November 19, 2013

RE: Hansen Boundary Line Adjustment (BL-13-00011),

Map Number 19-16-18052-0313 Parcel Number 567134
Map Number 19-16-18053-0009 Parcel Number 717134

Parcel # 567134 Boundary Line Adjustment

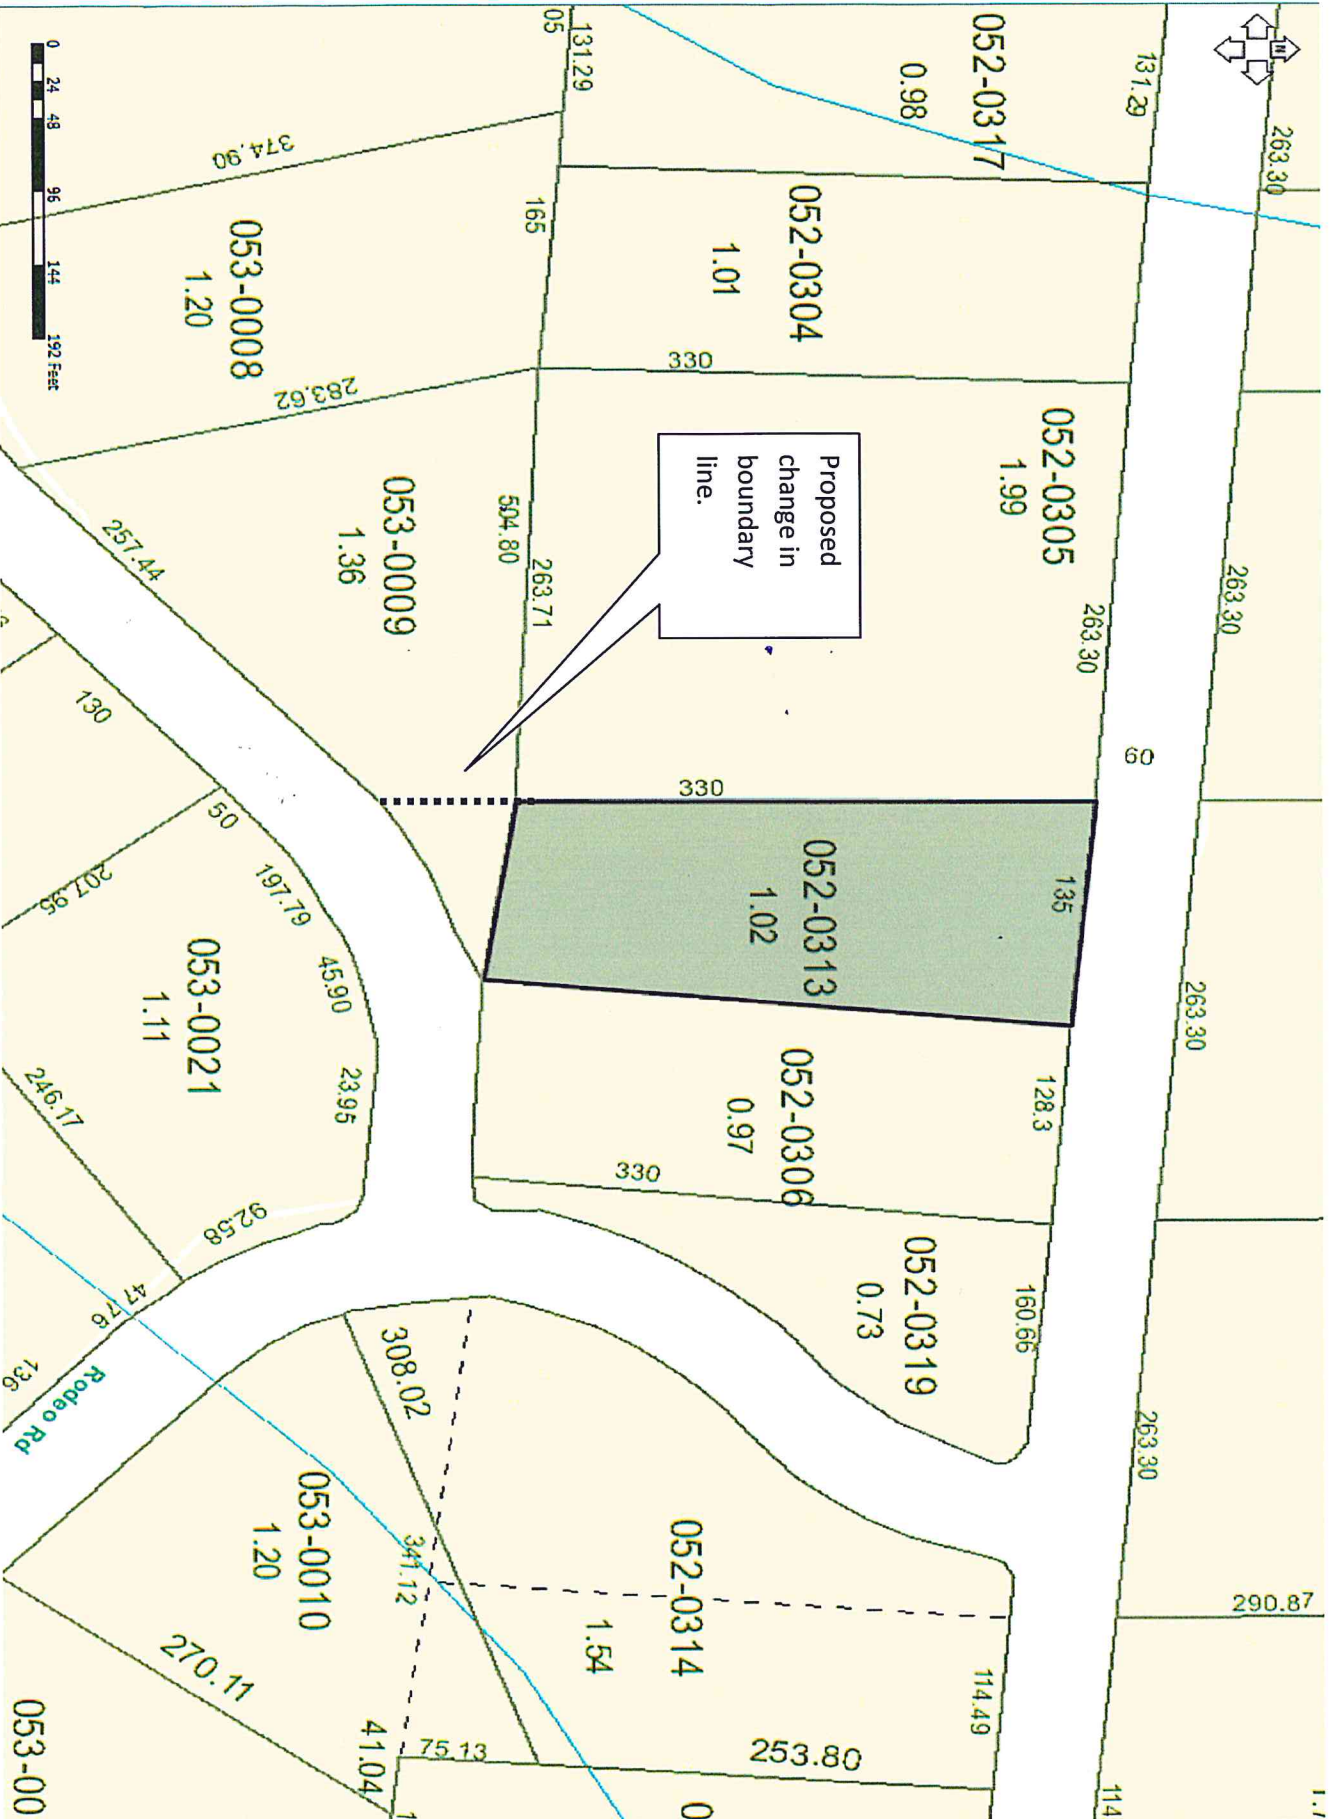
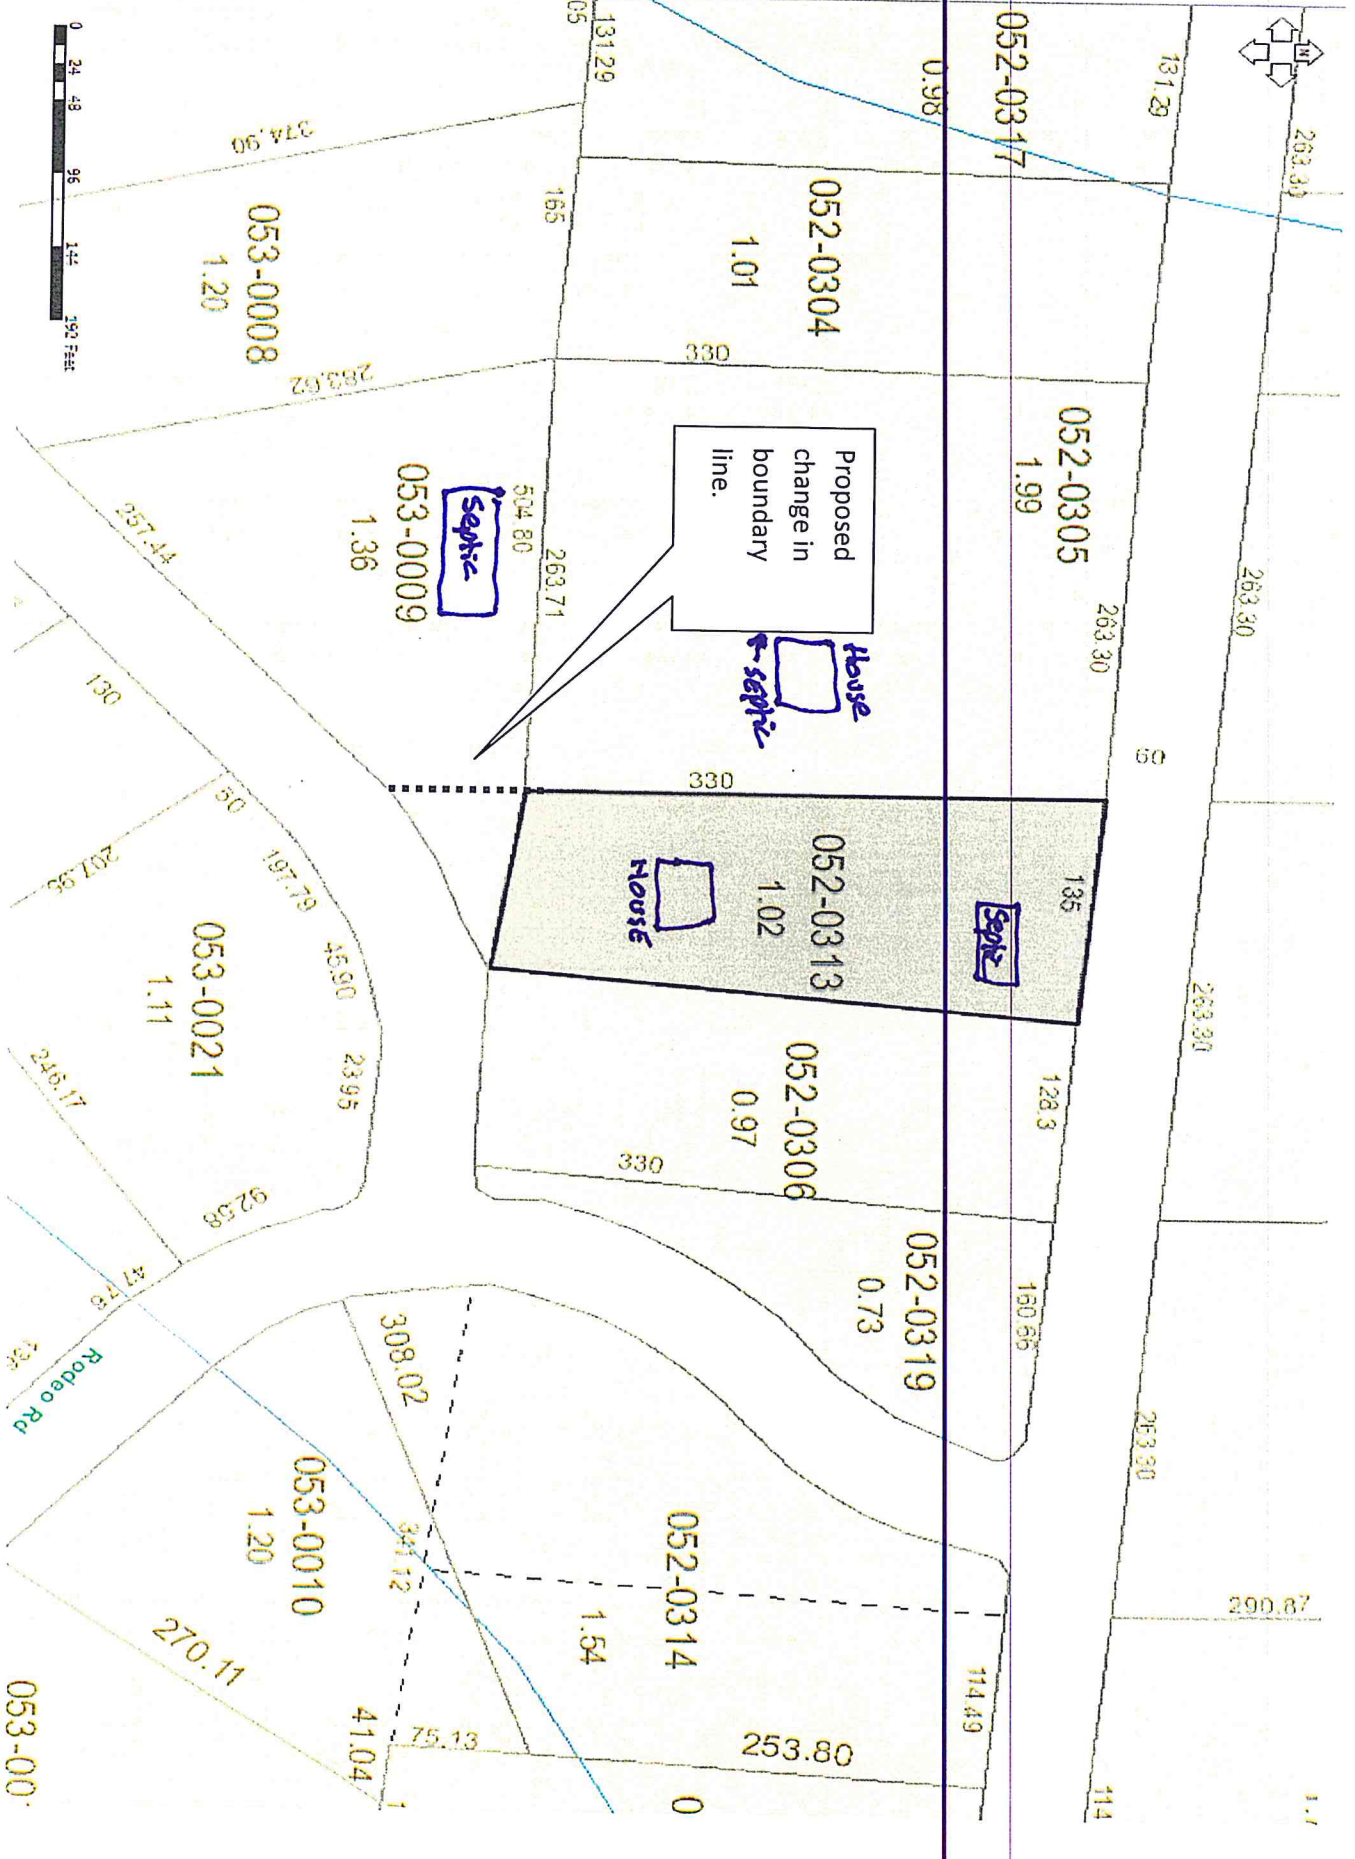
1. A metes and bounds legal description or recorded survey displaying legal descriptions and the new acreage and lot dimensions of each parcel must be submitted to our office prior to final approval. **Neither page three of the application or the legal description provided updated acreages for the parcels involved. Please see the attached email from the Assessor's Office for more details.**
2. Tax records indicate that the taxes have been paid for 2013 on all three parcels. If the conditions of approval are met prior to January 1, 2014, no further actions will be required. **If the required conditions are not met before the first of the year the 2014 full year's taxes will need to be paid prior to final approval.**
3. Please refer to the attached Kittitas County Public Works and Kittitas County Fire Marshall comment memos for information regarding additional requirements.
